**CITY OF ALBUQUERQUE  
PLANNING DEPARTMENT  
March 30, 2011  
DRB Comments**

**PROJECT # 1008735**

**APPLICATION # 11-70060**

**RE: Lot 1, Block 1, Dietz Farm Place**

PLAT OF
LOTS 1-A AND 1-B
DIETZ FARM PLACE
WITHIN
SECTION 31, TOWNSHIP 11 NORTH, RANGE 3 EAST, N.M.P.M.
CITY OF ALBUQUERQUE
BERNALILLO COUNTY, NEW MEXICO
FEBRUARY, 2017

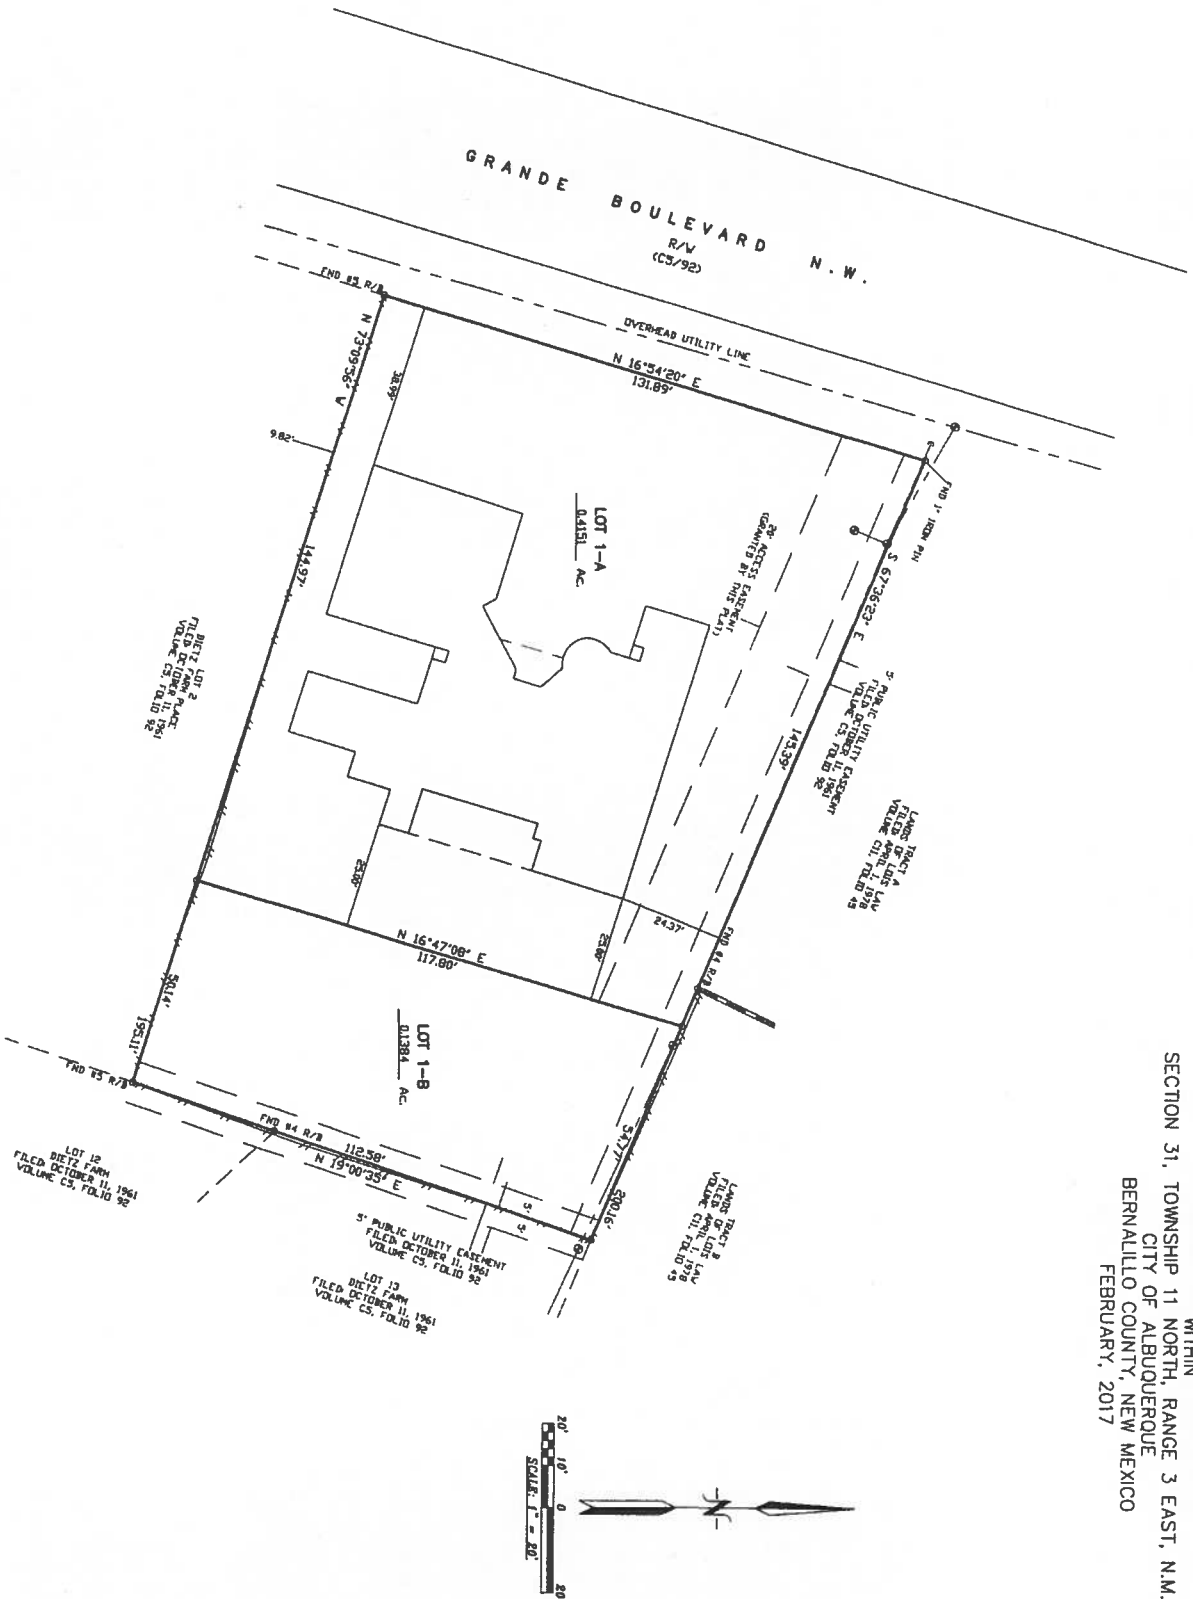
The northerly existing lot (Law-Lois) is outside of the City Limits and would need to be annexed in order to be included in any platting action of Lot 1. It is possible to record an easement on the northern lot and reference the easement on the division of Lot 1.

The minimum easement width would be 15 feet if it is only going to be a driveway for proposed Lot B, but if the driveway is going to be shared and used by 2 or lots then it would need to be a minimum 22 feet in width.
